**Physical Education for St Joseph's College, Mark Street, Hunters Hill (SSD 8970)  
Notice of Exhibition**

TfNSW has reviewed the relevant environmental assessments and provide the Department of Planning and Environment (DP&E) with following comments:

Drawing Title
**PROPOSED GROUND FLOOR
PLAN**

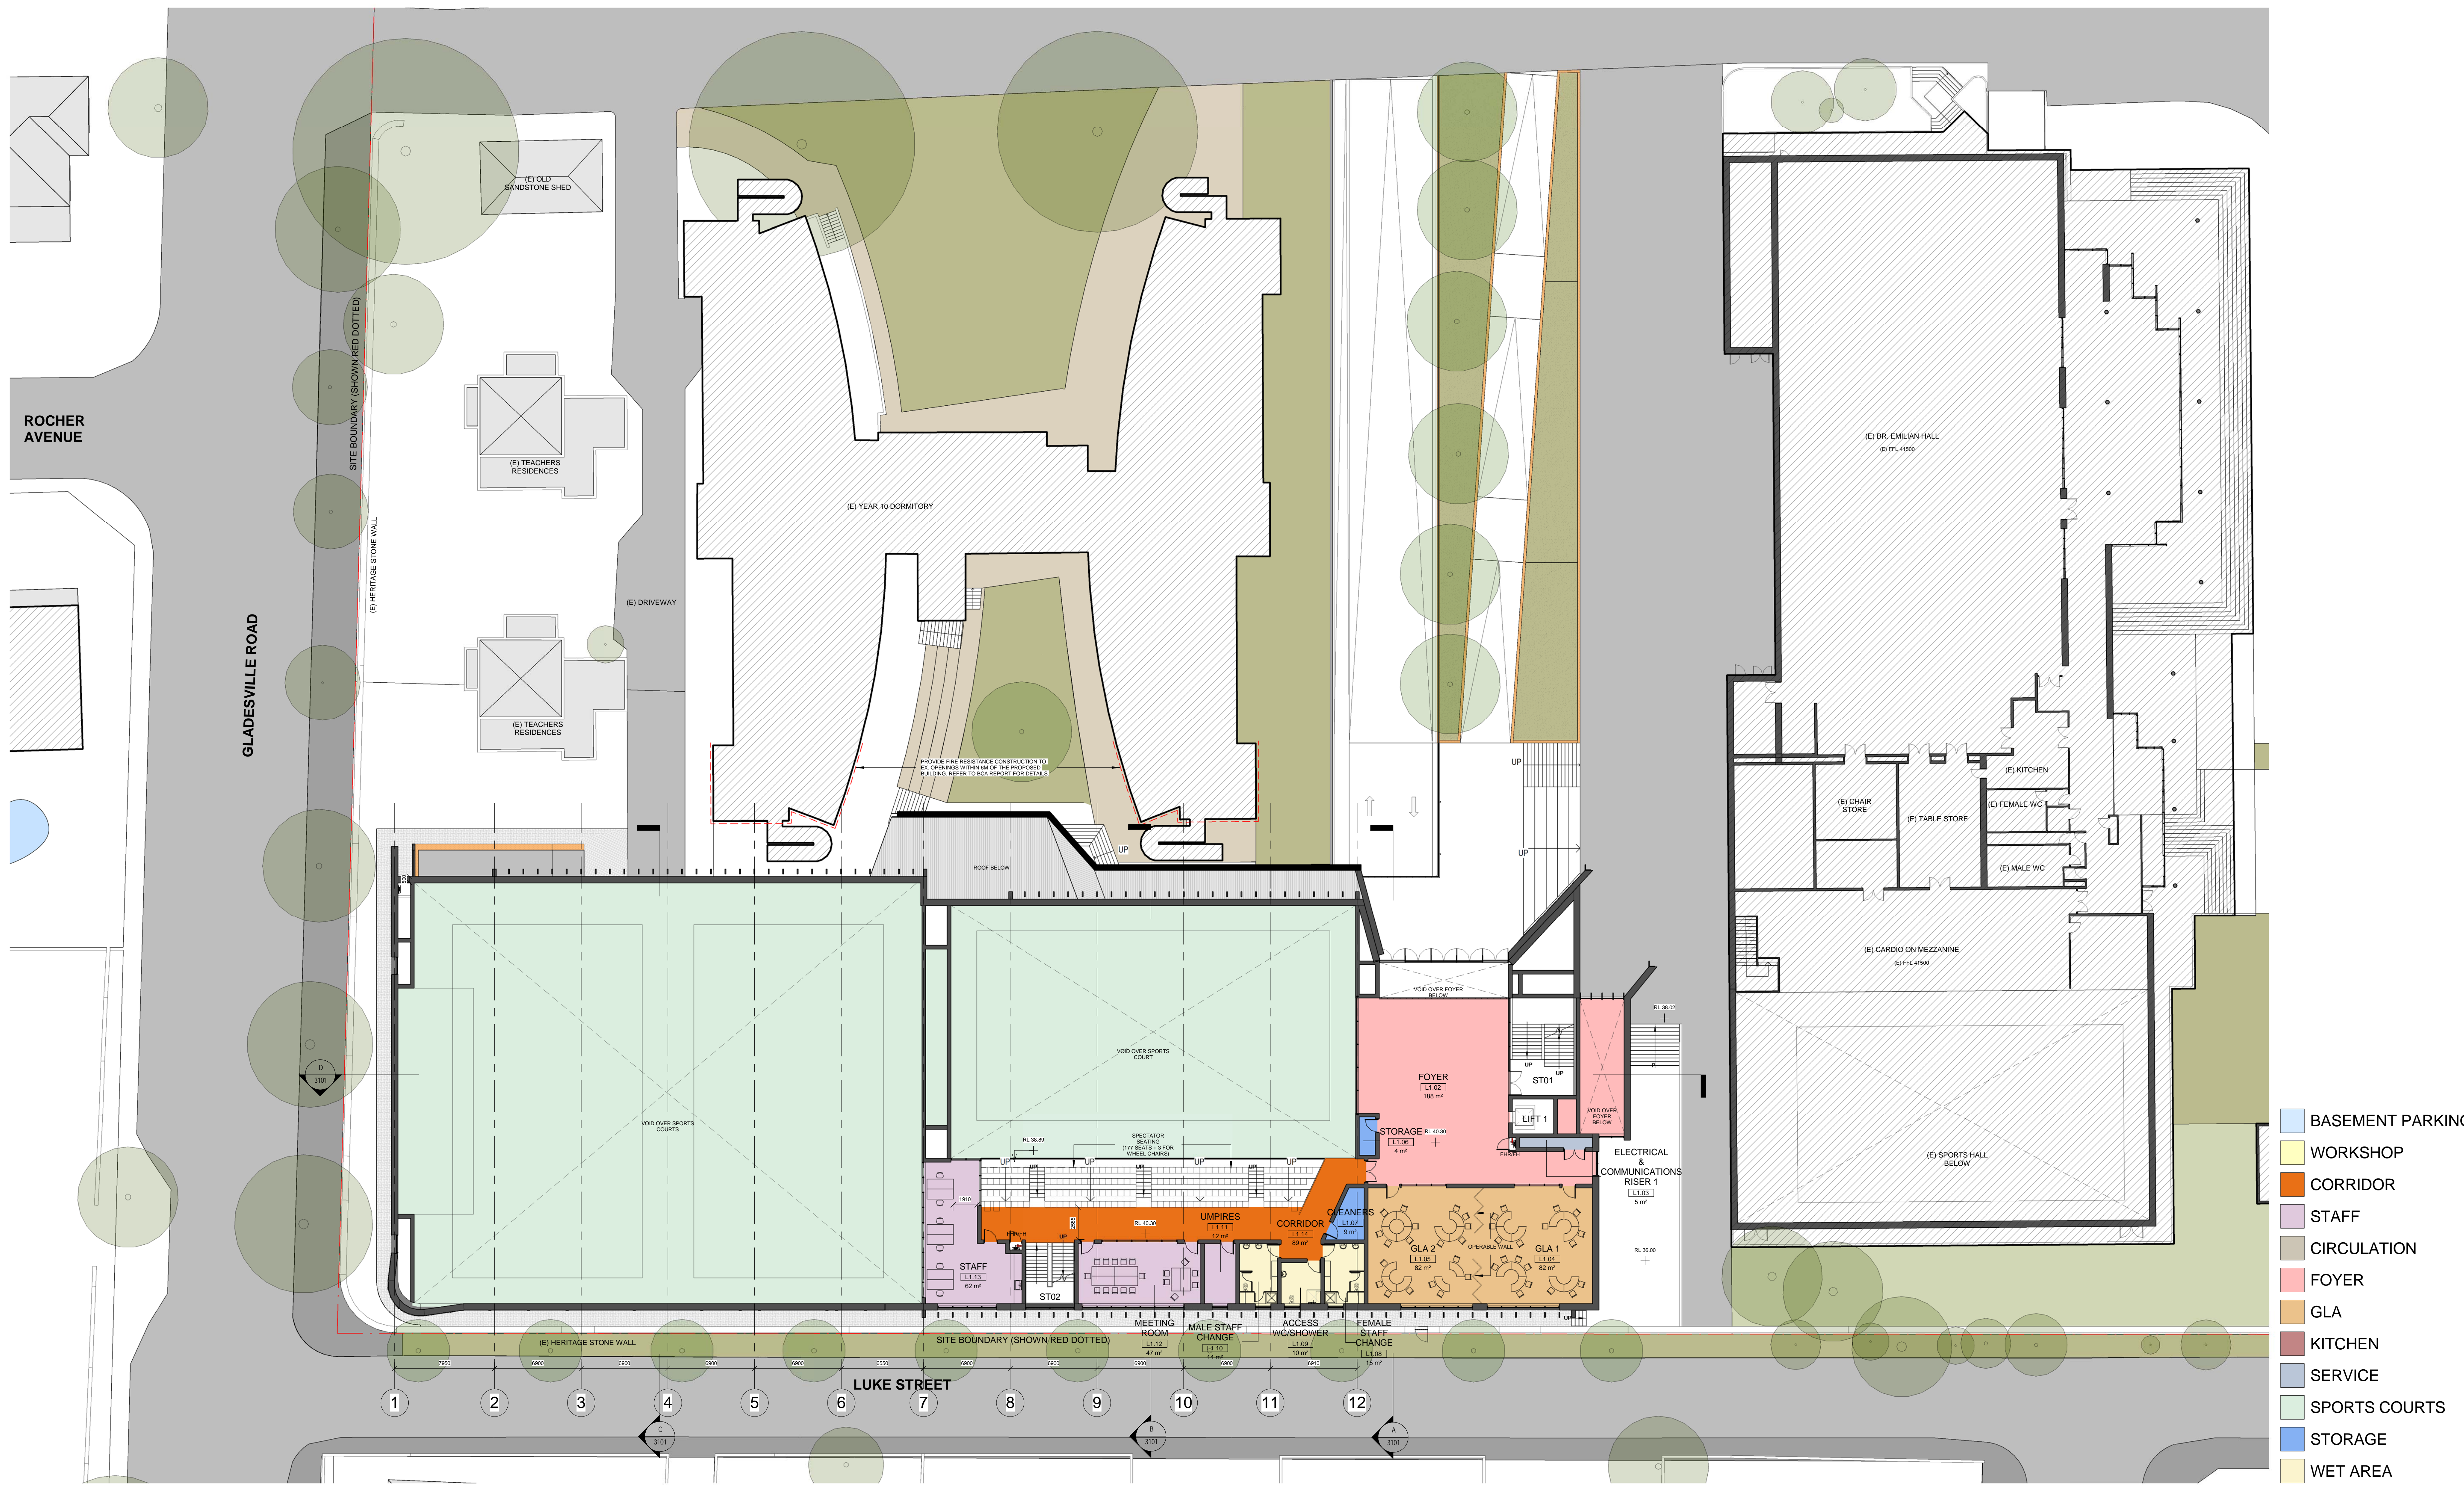
- The Traffic Impact Assessment (TIA) states that *"the proposal has identified a total of 38 spaces to be installed across the site in the form of secure bicycle racks"*. This quantity was assessed to be consistent with the NSW Planning Guidelines for Walking and Cycling. It is not clear on the plans as to where the 38 bicycle parking spaces are proposed to be provided.
- Suggested conditions of consent have been provided in **TAB A**, some of which have been based on the recommendations provided within the TIA.

A total of 38 bicycle parking spaces must be provided within the school site and designed in accordance with the requirements of *AS2890.3:2015 Parking facilities, Bicycle Parking*.
